Marge Schmuckal - shed application for 160 Massachusetts Ave

From: Marge Schmuckal
To: mollyg1967@aol.com
Date: 10/16/2013 4:45 PM
Subject: shed application for 160 Massachusetts Ave

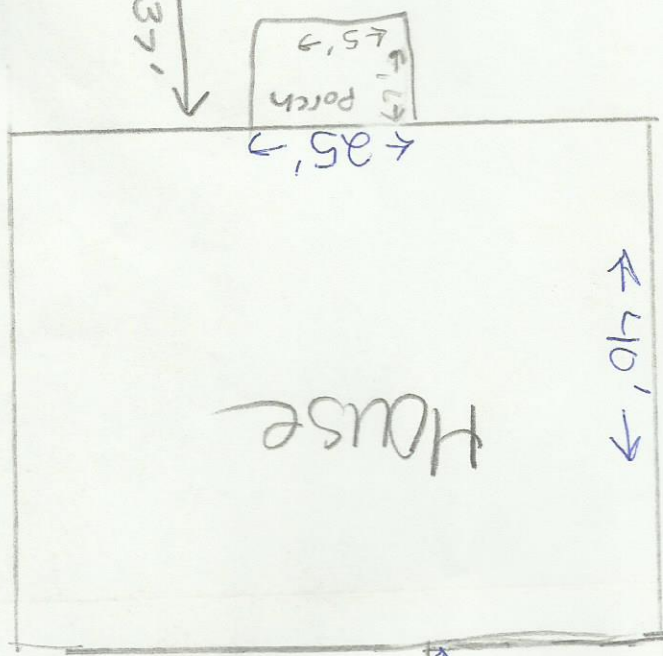
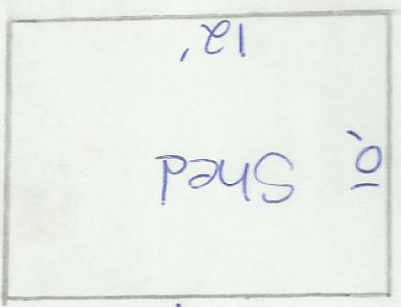
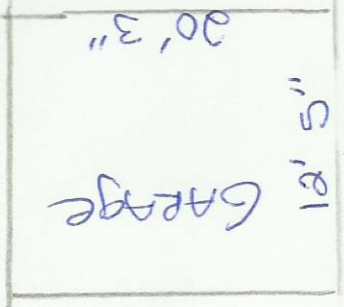
I am in receipt of your permit to erect a 10' x 12' shed at the rear of your property. Please note that sheds less than 144 square feet in size must be at least 5' to the rear and side property lines. Your plot plan shows that your shed will be closer than that minimum 5 foot. I can not issue you a permit at that setback shown. Your permit is on hold until I can receive a revised plot plan showing that you will be at least 5 foot from the rear and side property lines.
